Response to Planning Application

Application ref: AL/138/24/AOO

Description: Application for revised approval of the open space scheme as required under the second schedule, clause 1(a) of the section 106 dated 30-10-20 linked to Outline planning permission AL/21/20/OUT (previously approved under AL/97/23/AOO (in part) and AL/166/23/AOO).

Location: Land North of Lee's Yard Lidsey Road Woodgate PO20 3SU

Ordering No. CSA/5742/100	Rev
---------------------------	-----

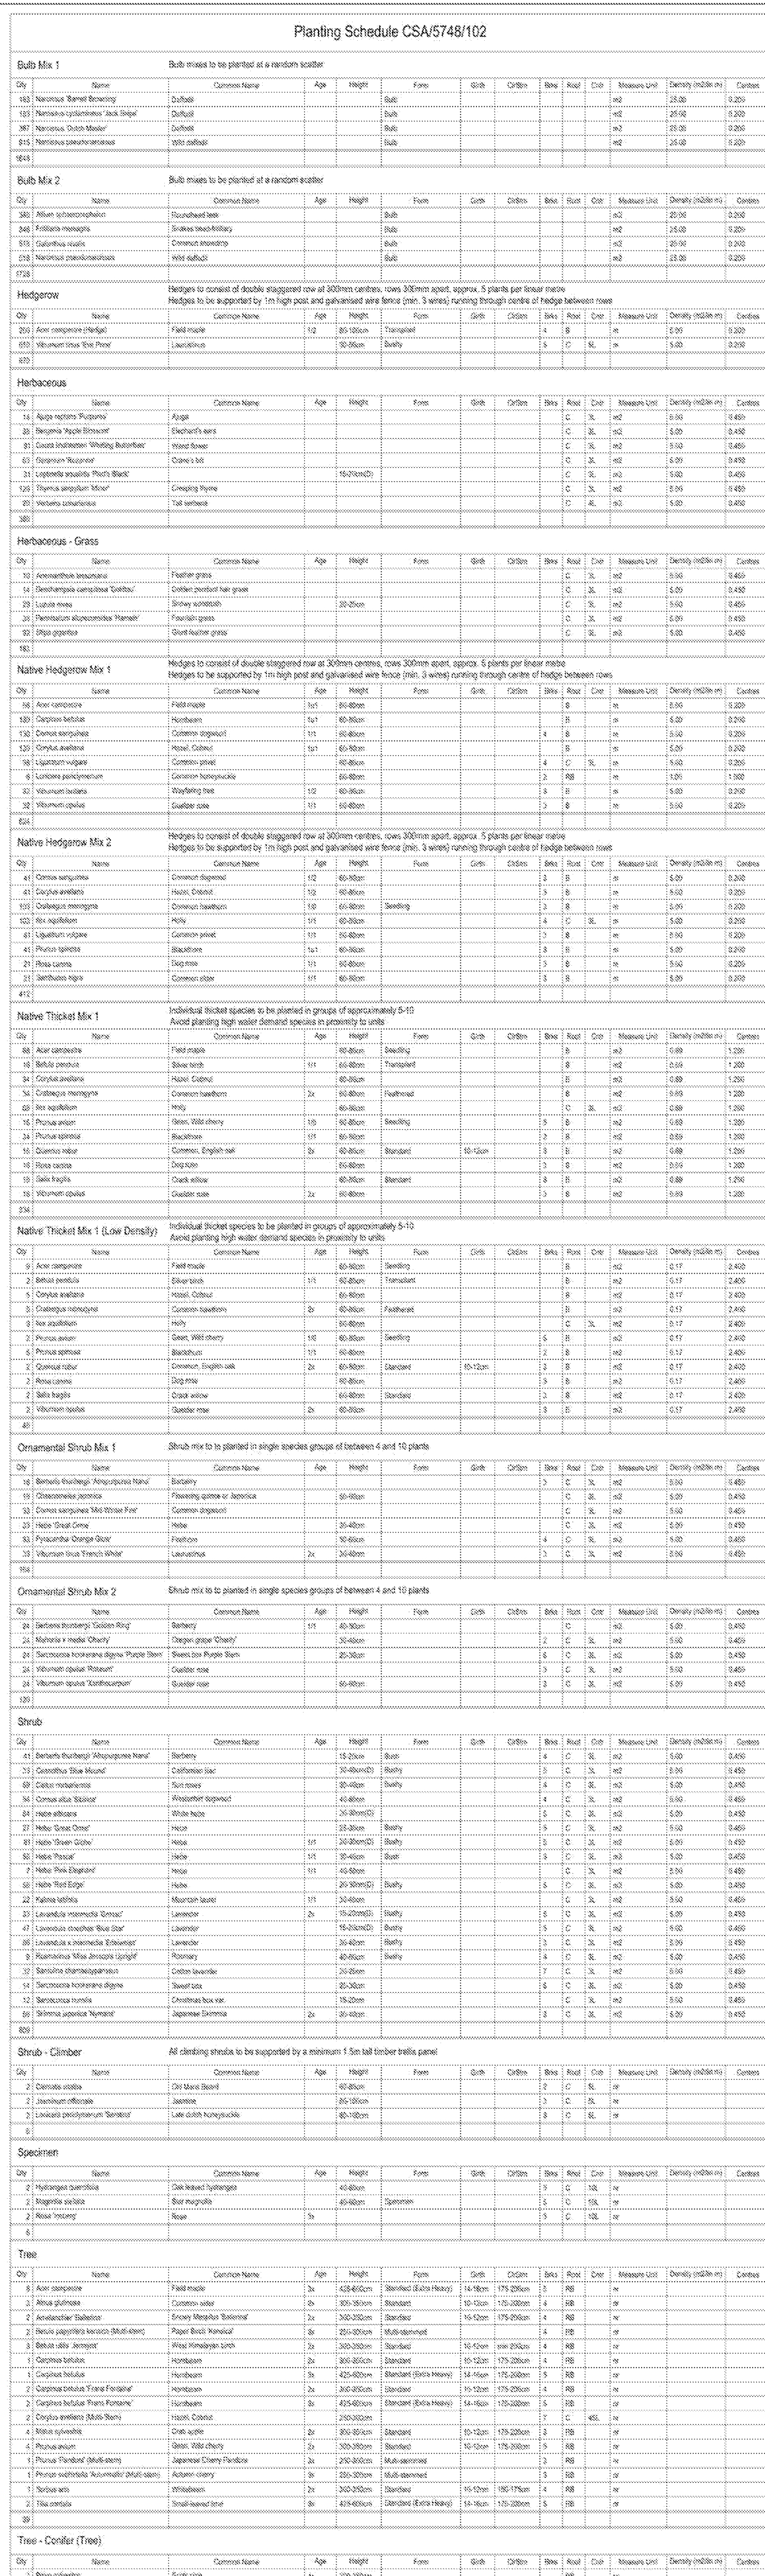
The proposals under this application are for an amend re the previously detailed community growing area to revert to Public Open Space for the development usage. The layout remains the same, a bench will replace the previously indicated shed and the area will be a useable asset to the development.
